Request for Additional information Prince of Wales Hospital SSD 18_9113

In response to your email dated 14 January 2019 requesting additional information for the above project, Health Infrastructure provides the following information.

SHADOW DIAGRAMS - 21
JUNE 3.00 PM
RCR-BVN-ARC-00-DRW-
01A-NL00031

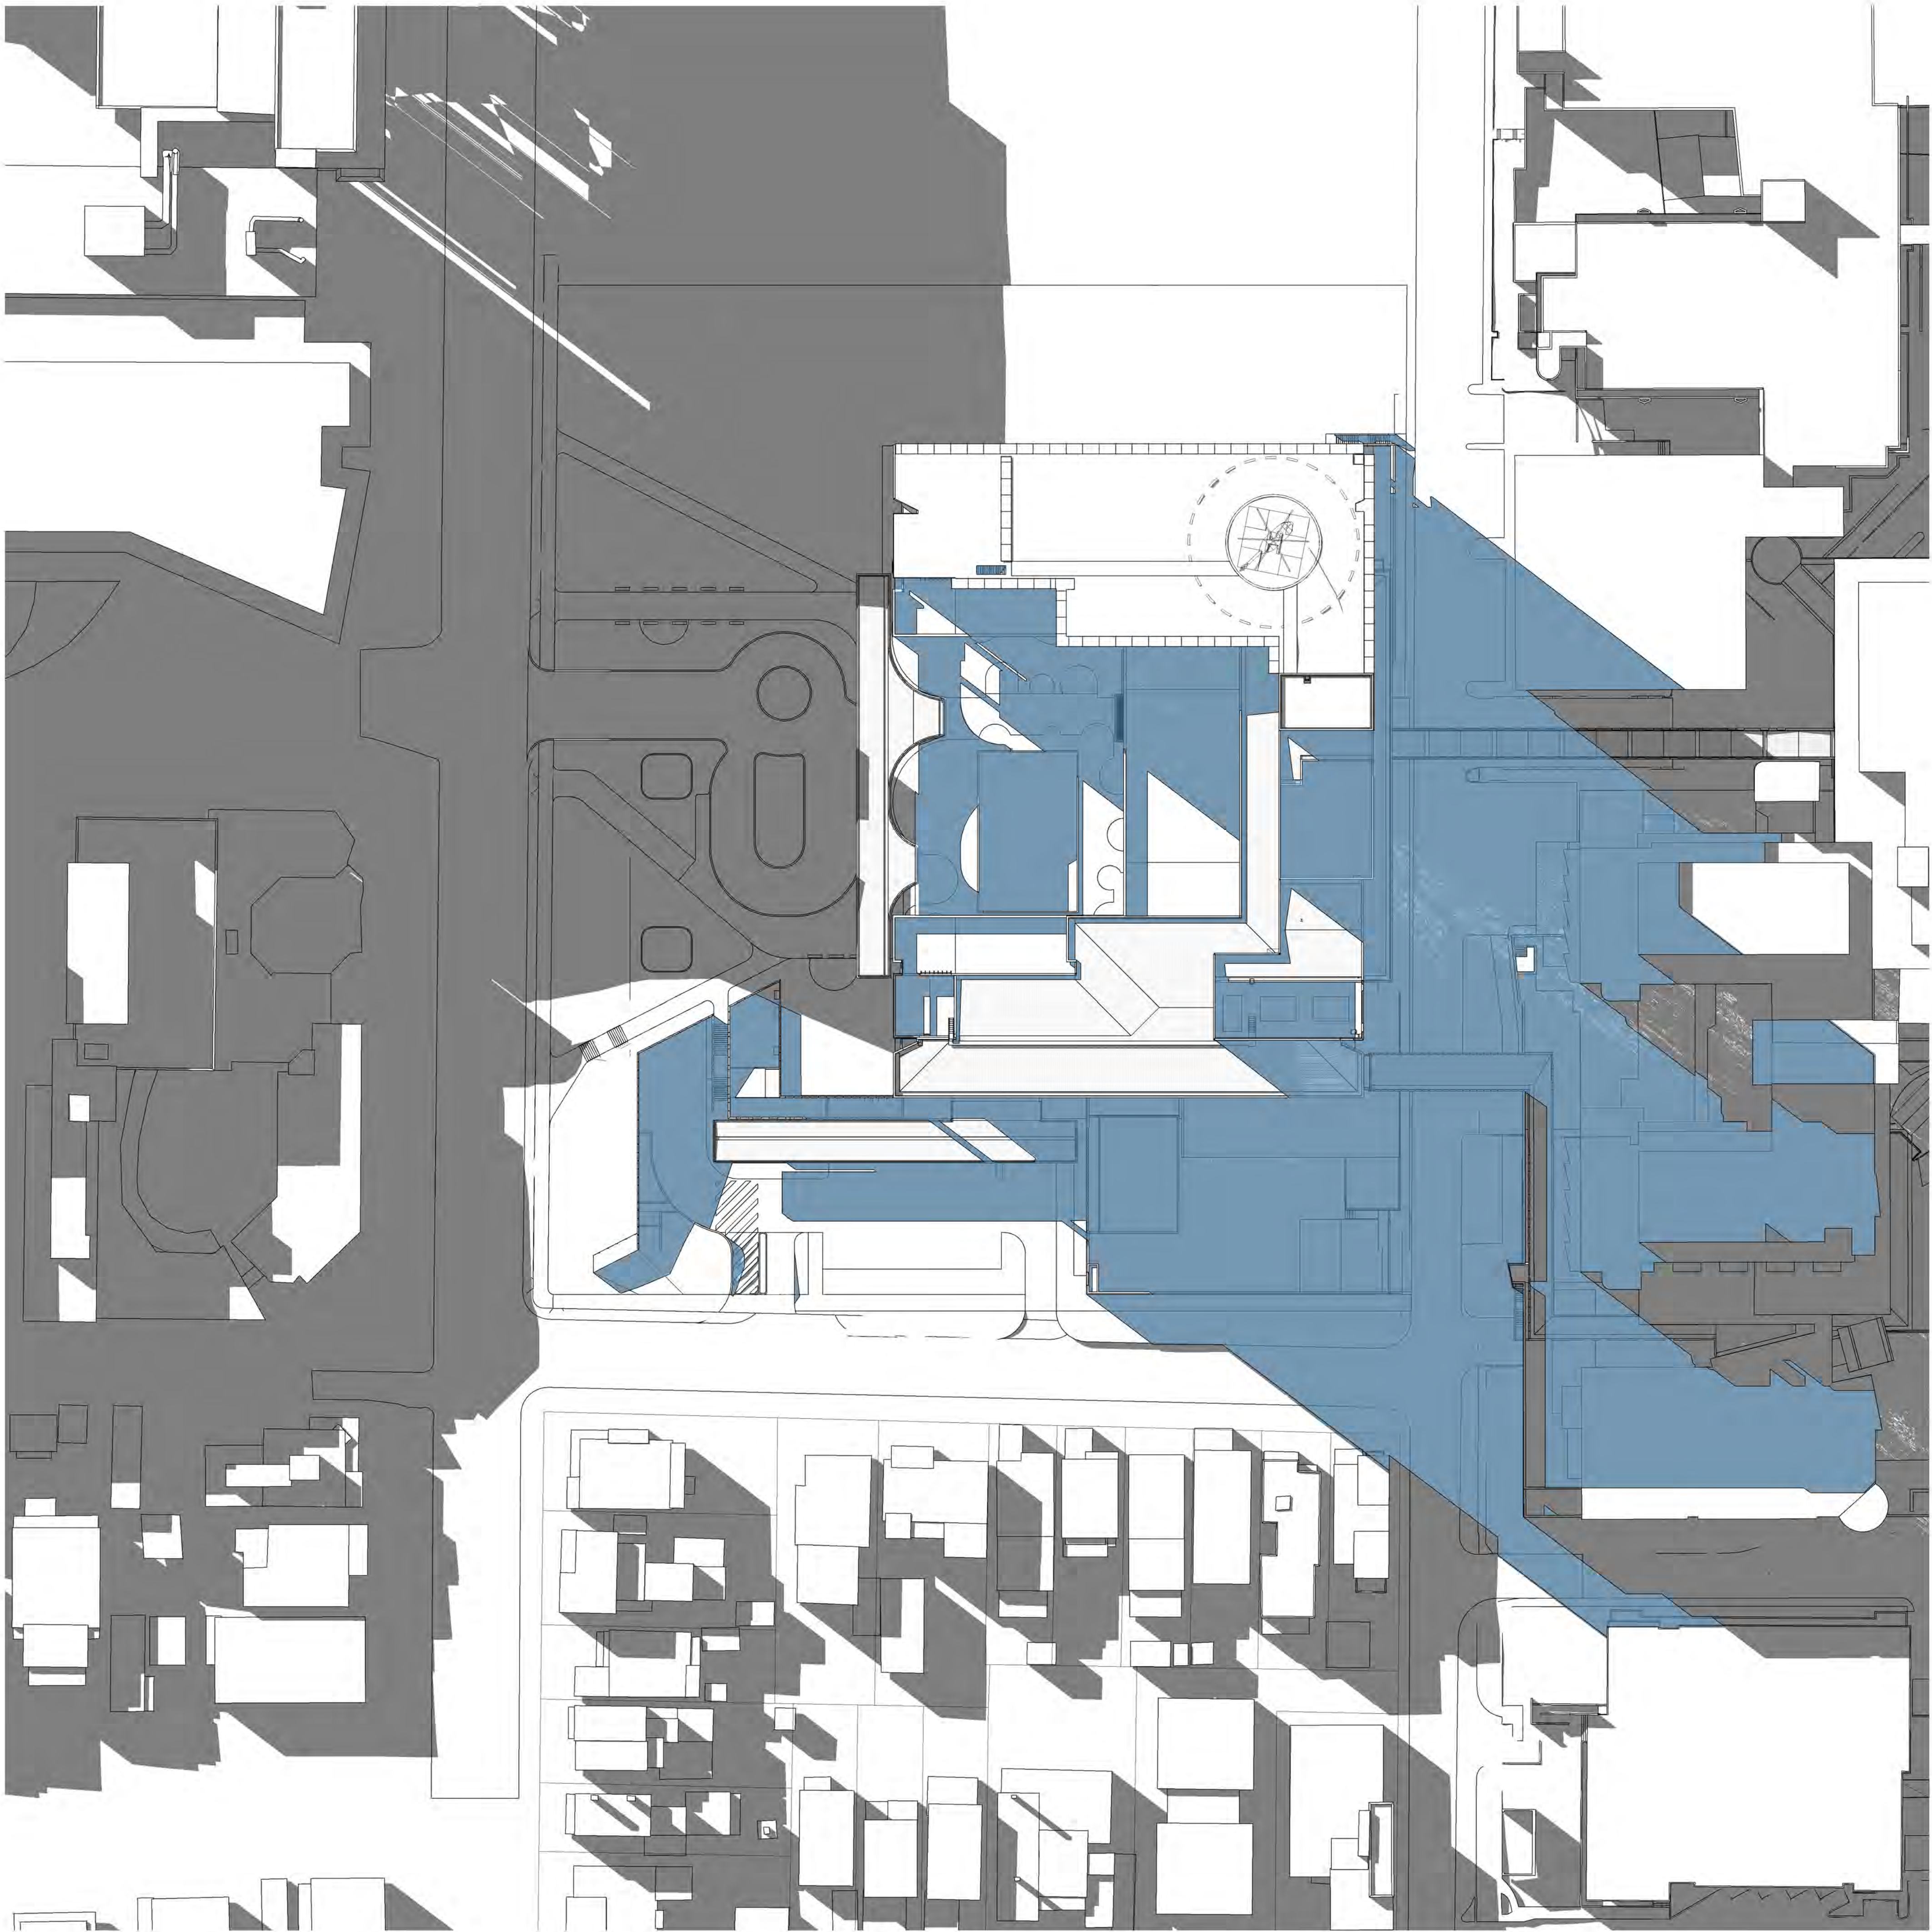
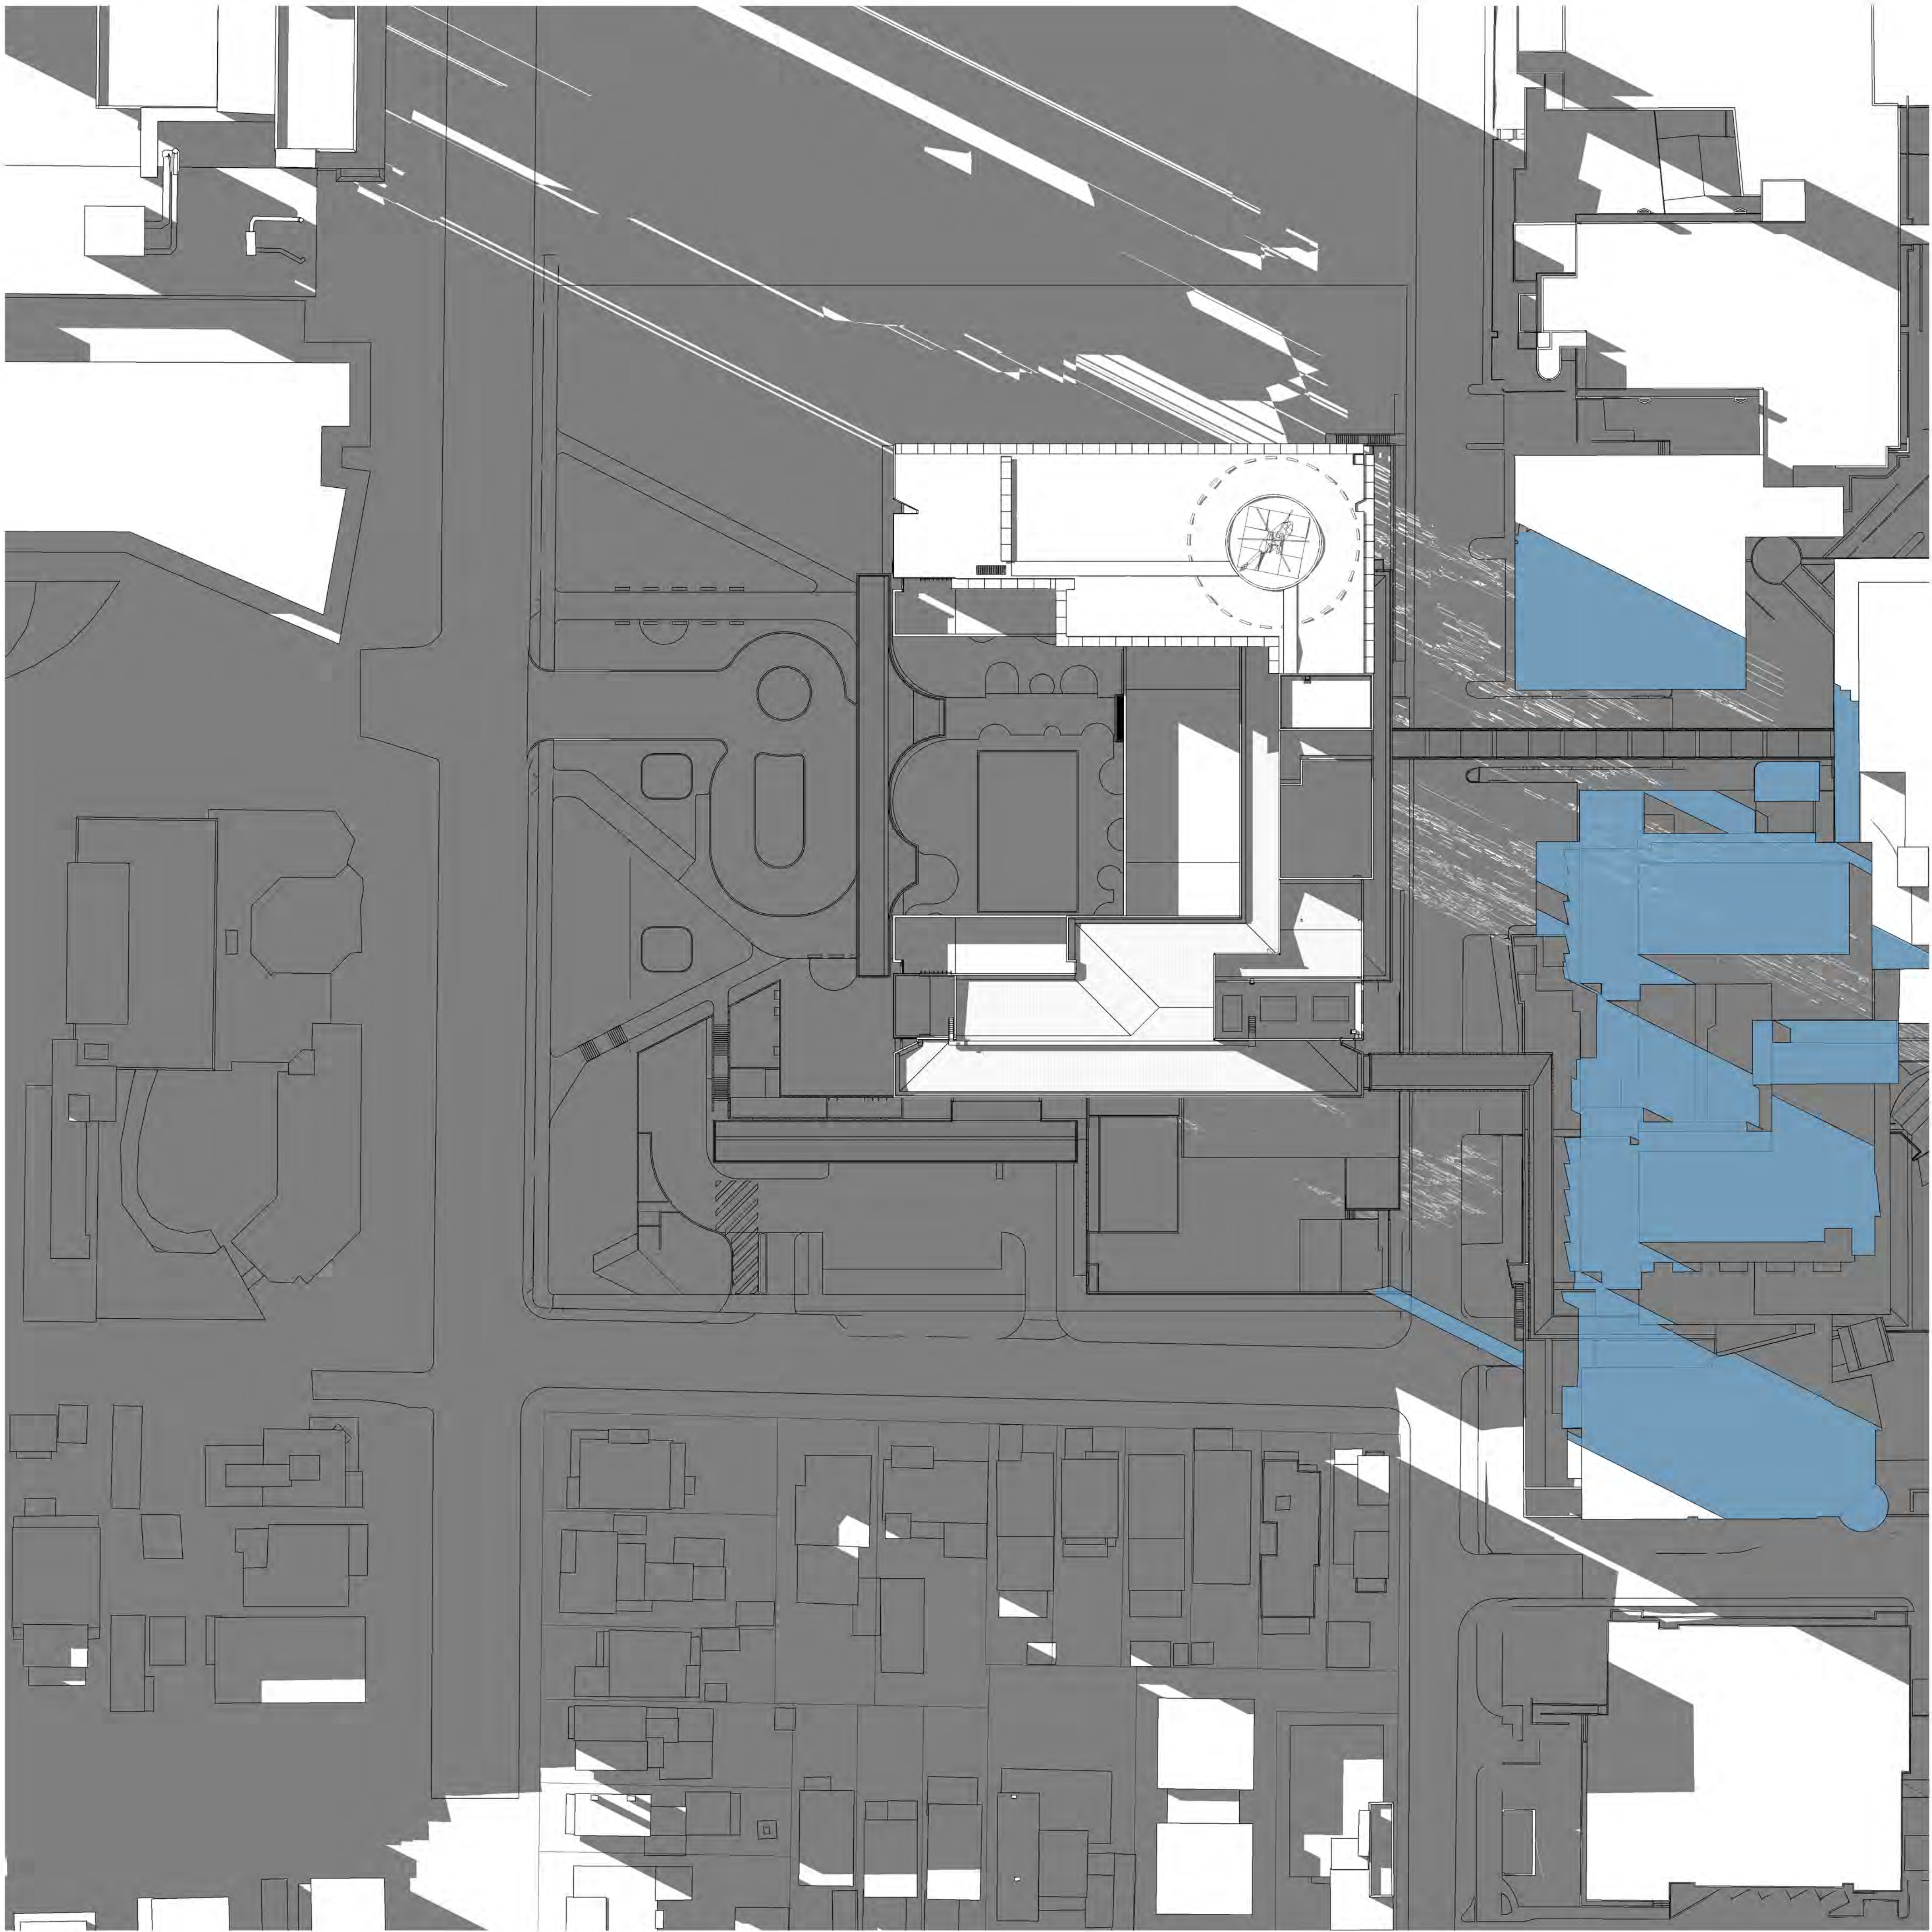
The additional information provided that the impacts on solar access are existing and that solar access is a DCP requirement that doesn't apply to SSD applications. It is noted that the DCP does not apply, however the assessment of the application must include consideration of amenity impacts and the Department considers that a minimum of 3 hours solar access to private open space and the primary living areas of neighbouring residential properties to be an appropriate guideline. It is acknowledged that the overshadowing of the private open space of dwellings located along both Magill Street and Botany Street is primarily existing. However, the application does not identify the living spaces in the Magill Street residences and as such, the impacts of the proposed ASB cannot be ascertained. As the ASB will significantly overshadow the front elevation of the Magill Street residences, the location of the living spaces in these dwellings is required to complete our assessment.

Attachment A provides details in respect to the relevant residences in Magill Street and the location of their living areas. This information confirms the assumptions that were made in Section 7.3 of the exhibited EIS.
